Luke Foley MP

18 August 2016

I make this submission with regards to **Application No SSD 7545, Forensic Pathology and Coroners Court**, Weeroona Road, Lidcombe.

Figure 9 – Site Access Road

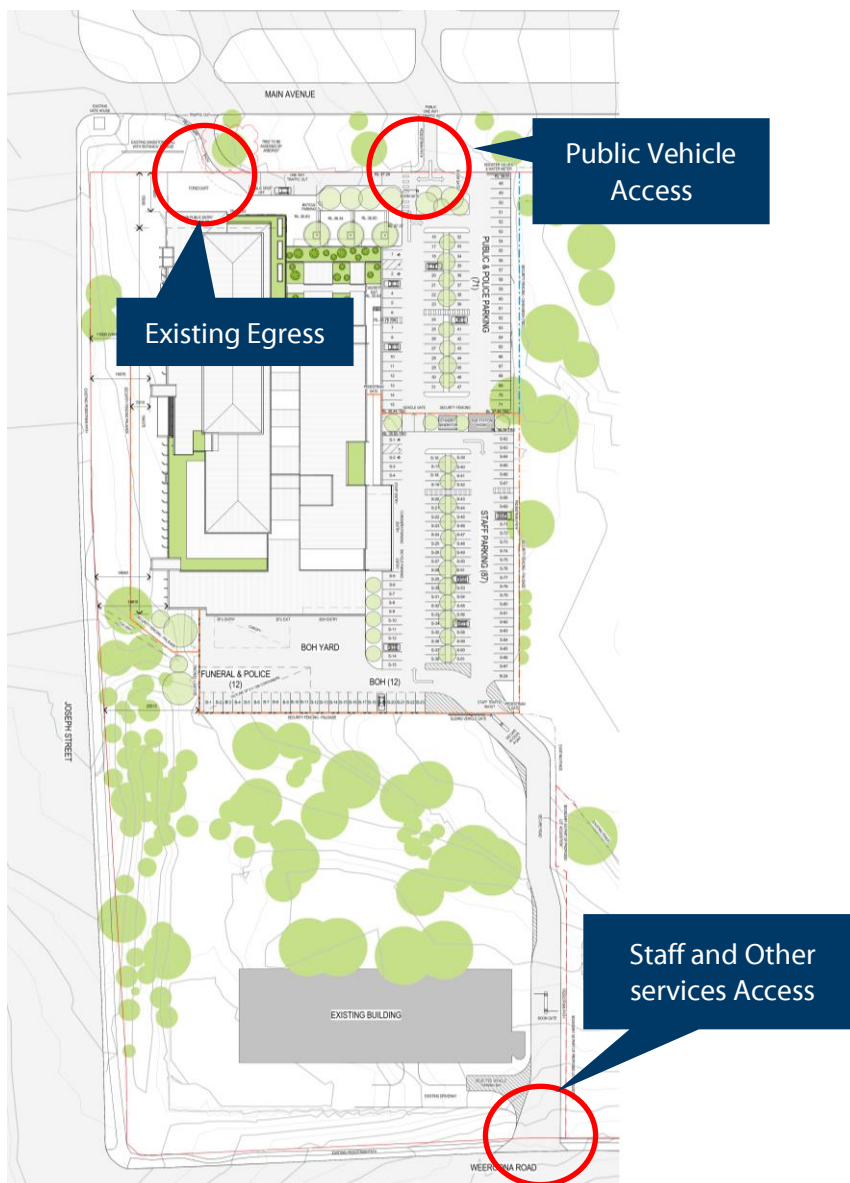
- The proposed public entry/exit via Main Avenue to the new Forensic Pathology and Coroner's Court is inappropriate. Main Avenue is a classified local road with a 50kph speed limit. The carriageway accommodates one lane in each direction and is accessible via a left slip lane from Joseph Street. Other streets within the Botanica Estate are narrow residential streets that only accommodate local traffic and local bus services. The proposal for a driveway connecting the public car park with Main Avenue would compromise road safety and dramatically increase traffic movements throughout Botanica.

- If the public entry/exit to the new Forensic Pathology and Coroners Court is via Main Avenue then any visitors heading north will need to find an alternate route through

the residential streets of Botanica as Main Avenue only provides an exit southbound onto Joseph Street.

- The avenue of Hoop Pines and Phoenix Palms along Main Avenue is also graded ***as an element of exceptional significance*** in the CMP. Construction of the proposed public entry/exit from Main Avenue, Botanica will require destruction of the historic brickwork and verges and interrupt the streetscape.

I share residents' objections to the public entry/exit to the Forensic Pathology and Coroners Court from Main Avenue. **Alternatively, Joseph Street or Weeroona Road should be the designated access to reduce the impact of this development on existing residences and roadways.**
